Planning Application Ref: BR/153/17/RES

Location: 3 Southdown Road, Bognor Regis

Description of works: Reserved Matters Application – Tree Protection Issues

Project:	3 Southdown Road
Drawing Title:	Landscaping Proposals & Planting Plan
Purpose:	Planning
Dwg. No.	1022-5300
Scale:	1:100 @ A1
Date:	20-May-2017

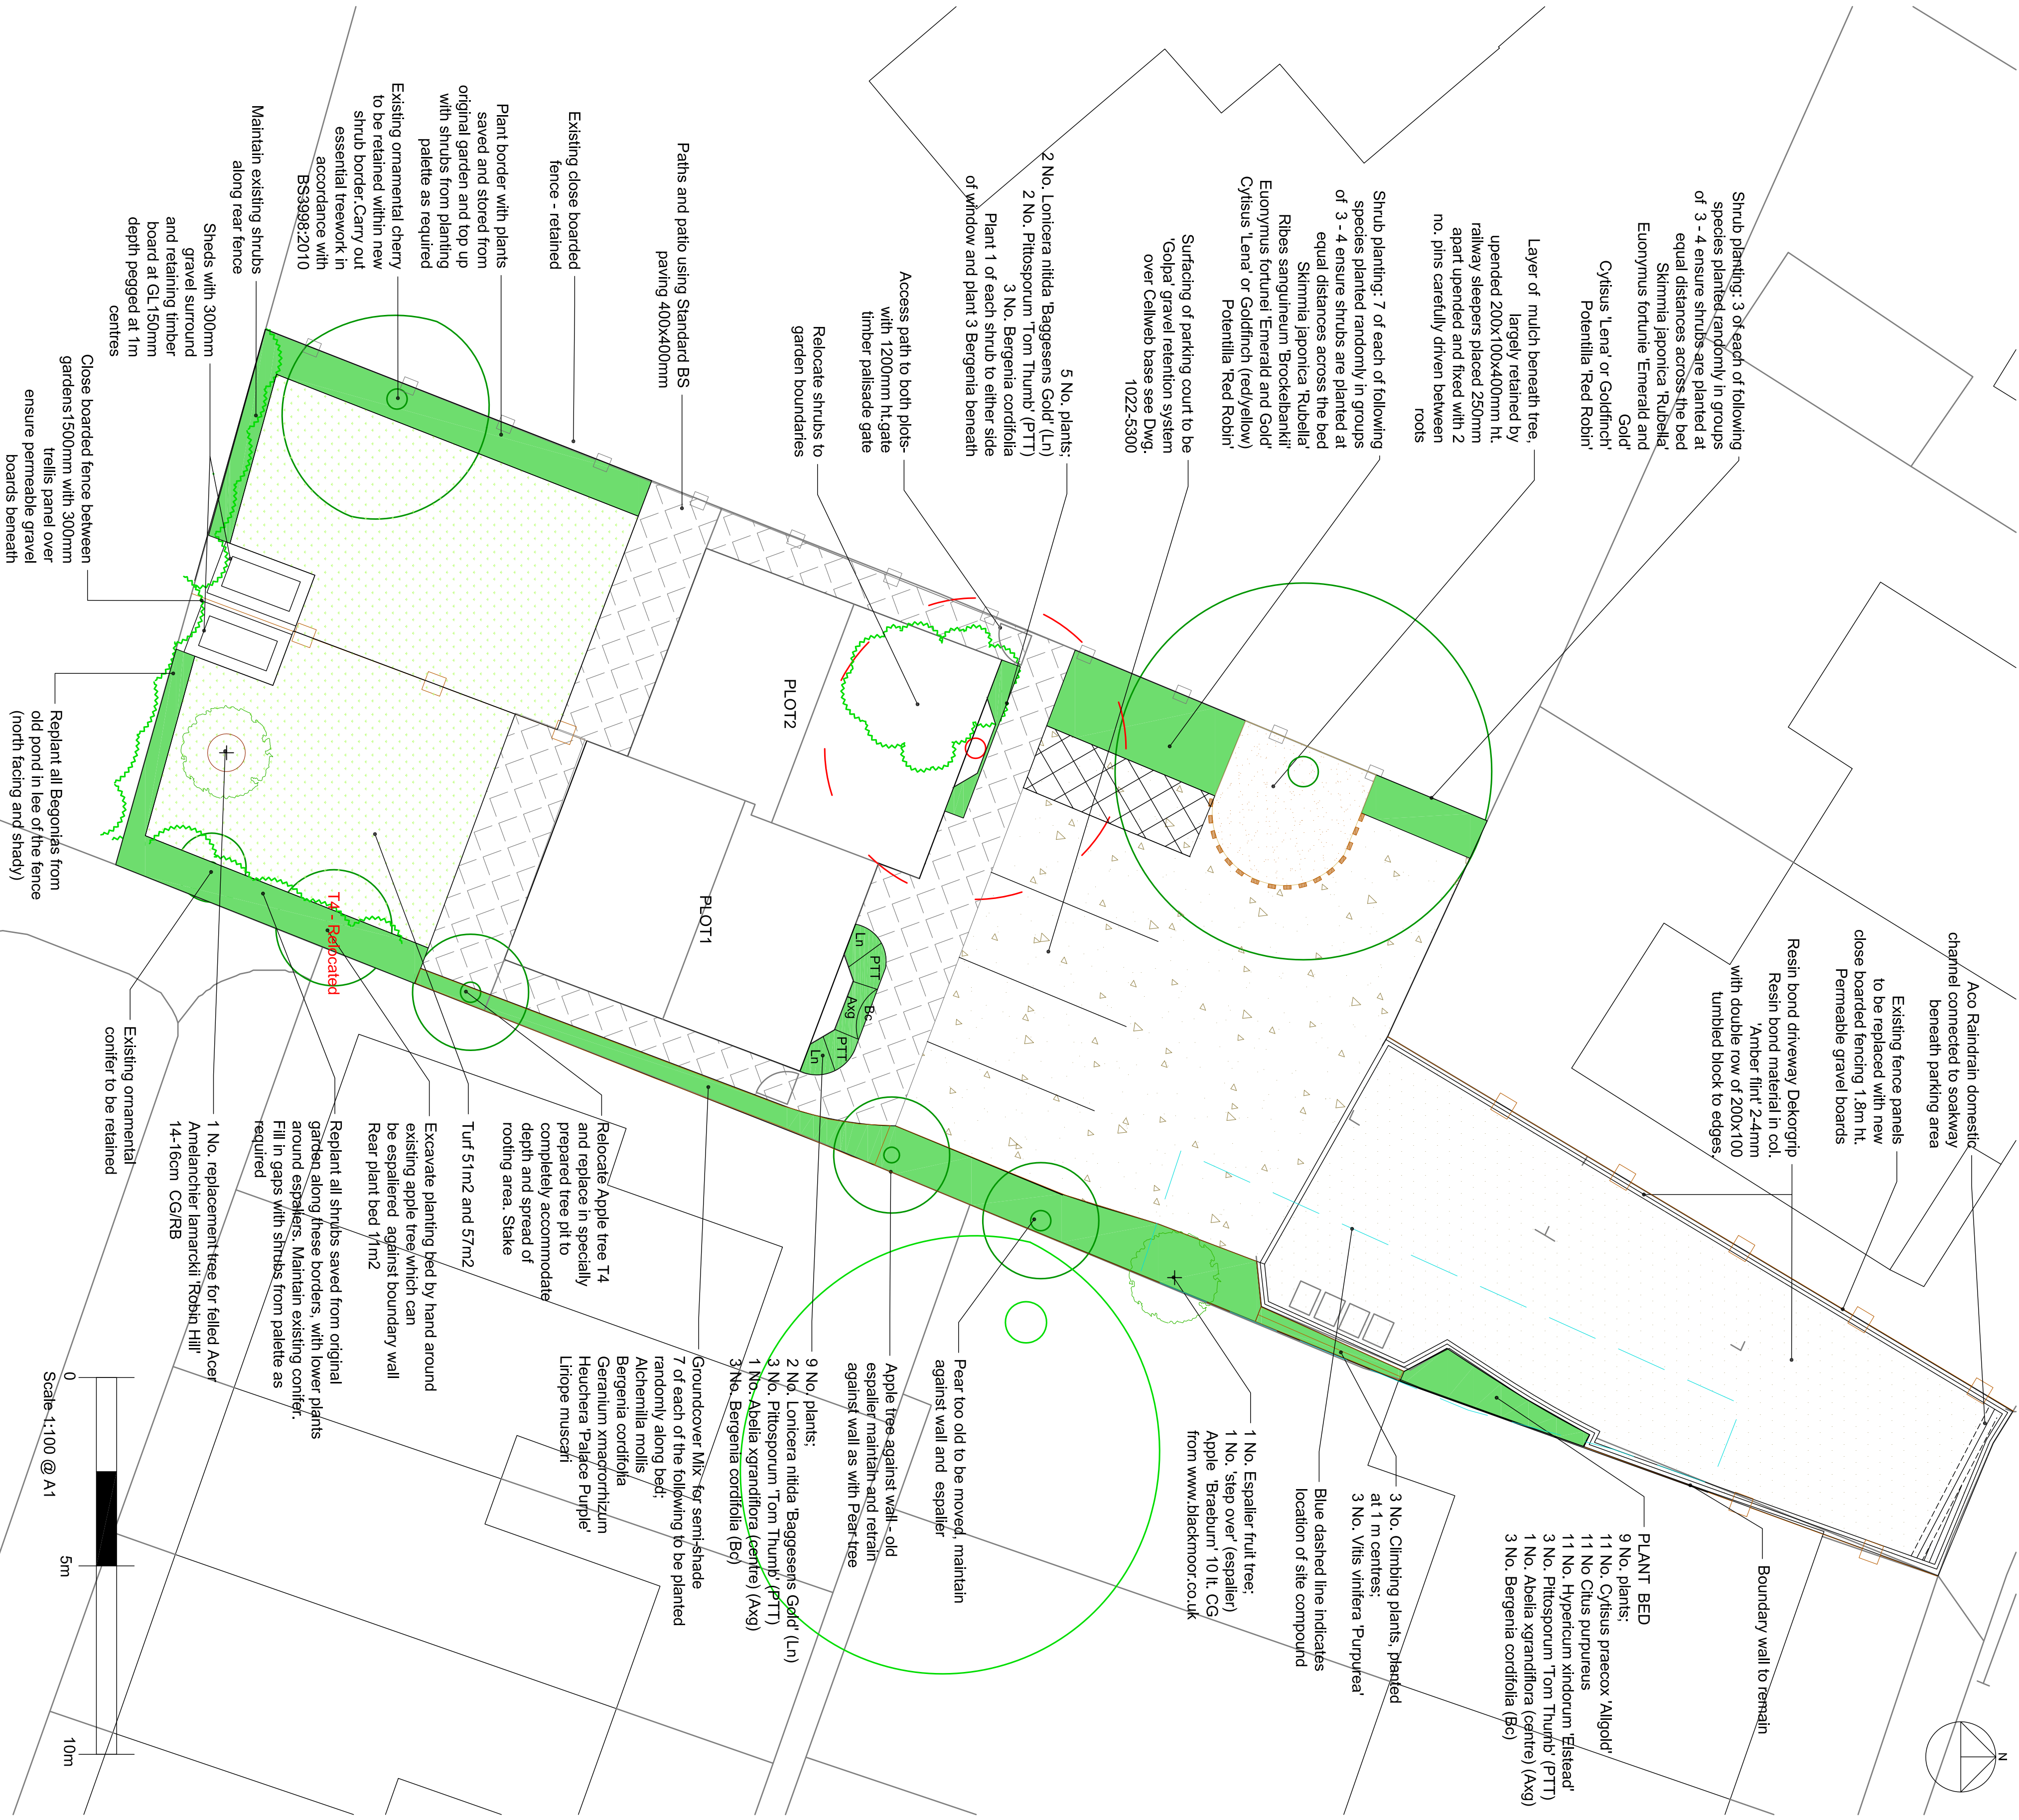
- I have studied the Tree Protection Plan and it is very detailed and the measures recommended are adequate to ensure that the on-site Tulip tree and off site Oak (a very poor and crudely mutilated tree) are protected provided that the following sequence of events takes place:-

1. This is a tight site and as the new buildings will be at the rear of the Plot so it will be imperative that the ground within the RPA of the two retained trees is protected for the duration of the Construction process. On the assumption that dumper trucks and/or forward loaders will be used for this work the ground protection will need to be BS5837 Section 6.2.3.3 b) compliant – *‘for pedestrian operated plant up to a gross weight of 2t proprietary interlinked ground protection boards placed on top of a compression resistant layer of 150mm depth woodchip laid onto a geotextile membrane’* They should notify the planning department when this has been installed so that the Tree Officer can then attend site with the Landscape Architect to verify that it is of the desired quality and ‘fit for purpose’ At the same time the other tree protection fencing can also be inspected.

2. On completion of all building works and removal of machinery from site the ground protection measures will need to be lifted to facilitate construction of the porous ‘No Dig’ Golpla cellular confinement system over the CellWeb sub-base layer all filled with washed gravel.
